Reg Identification no 20054324

Re- Botley West Solar Farm

We are writing this letter to express our deep concerns over the recently submitted planning application for the development at the above site: specifically, the planned provision of a visitor education centre adjacent to the recreation centre in Bladon.

**Operational Development Plan
Central Site Area 1 of 4**

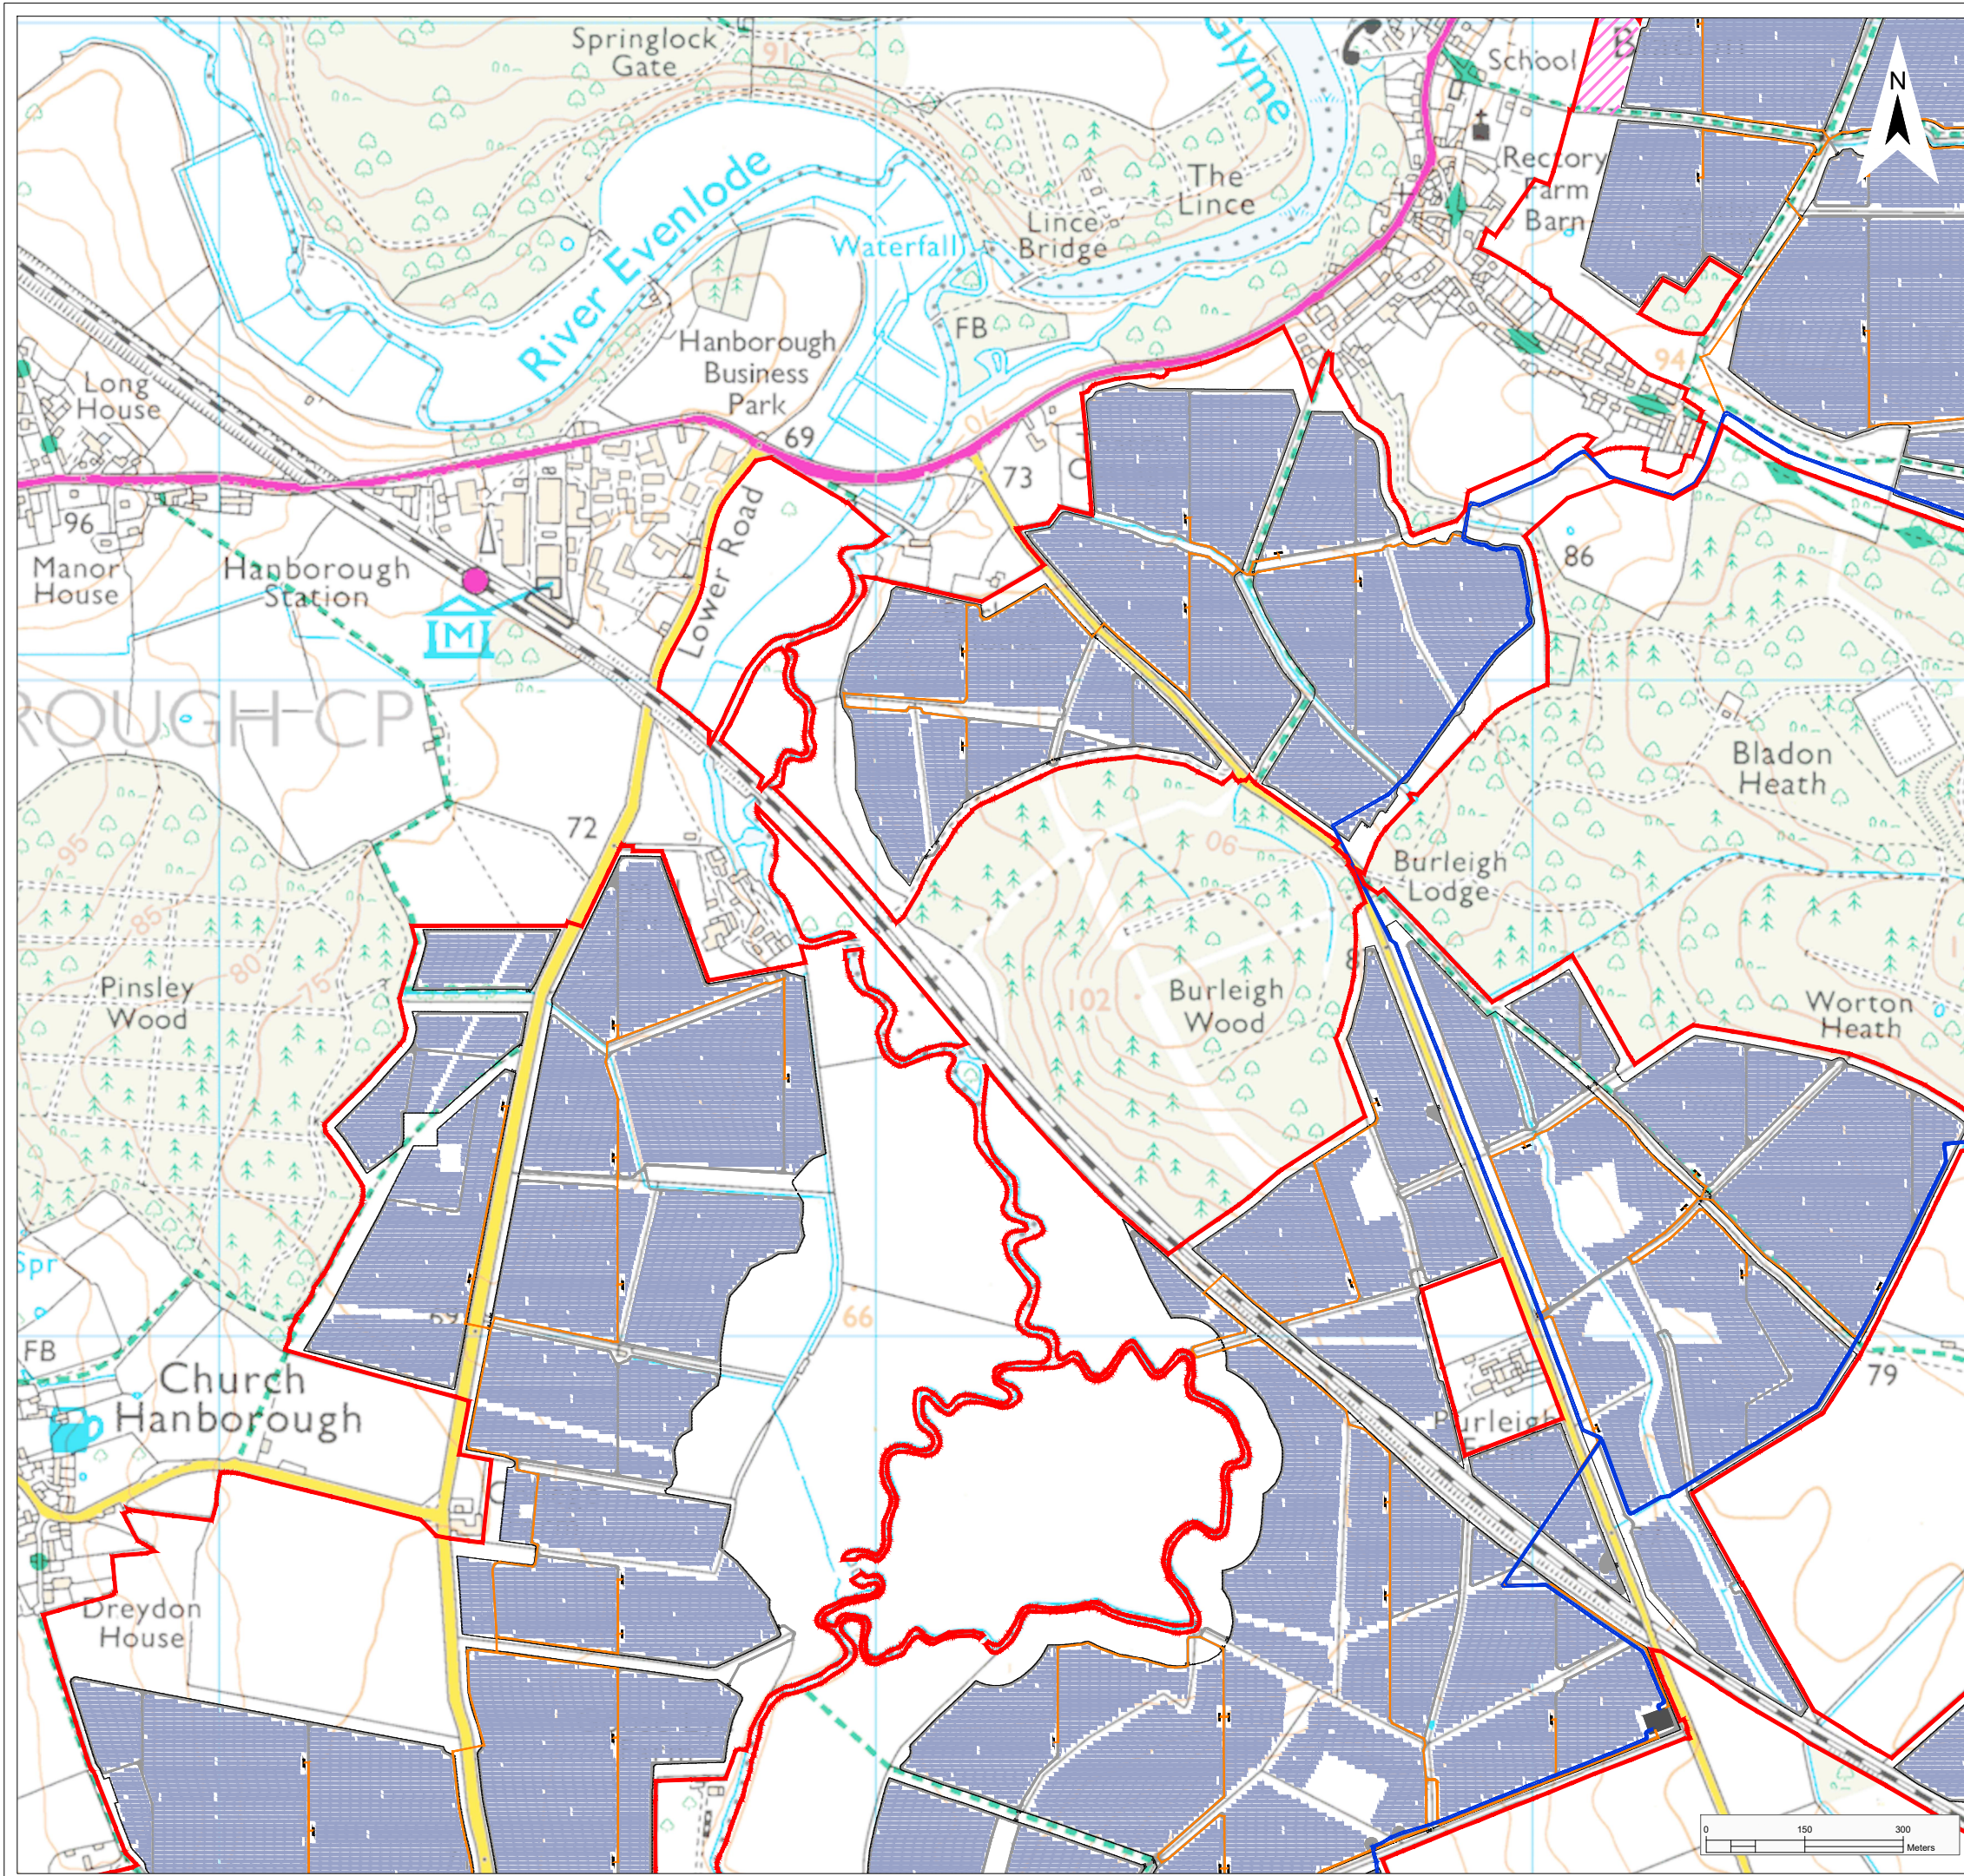
A potential location was identified to the east of Bladon, on land adjoining existing community facilities (land next to a playground, MUGA, and Botley West Solar Farm Applicant's Response to the ExA's First Written Questions [EN010147/APP/12.2] Rev P0 July 2025 Page 174 ExQ1 Question to Question Applicant's Response allotments) and ***where there is a suitable vehicular and pedestrian access, which also serves the Bladon Primary School and the Parish church.***

If you have visited this site, you will have noticed that the vehicle access from A4095 Grove Road, is restricted to one vehicle only with very poor visibility along its length, resulting in vehicles only seeing oncoming vehicles at the last minute. This results in vehicles having to reverse backwards uphill with limited visibility or reverse back onto the main A4095- this is clearly extremely hazardous and against the highway code.

This narrow lane is used by small children and their parents for pedestrian access to school twice a day. These children ride bicycles and have limited control particularly coming downhill towards the main road. Also, we have coach visitors to Winston Churchills grave, so during the day this lane becomes very busy with pedestrians.

There is NO parking within school lane and no vehicles beyond the church car park, due to resident's properties. Where you have stated "there is suitable vehicular access and minibus parking" needs to be questioned.

Due to restricted visibility onto the A4095 (Grove Road) School Lane is entirely unsuitable to take the traffic that would be associated with the proposed development. Why an education site has been earmarked in Bladon needs questioning. There can be no guarantee of safe emergency vehicle access to the facility and the local Ambulance staff have advised the school an Ambulance cannot get to the school due to this lane's width in providing limited access. Having this education centre with more school children will be tempting fate.
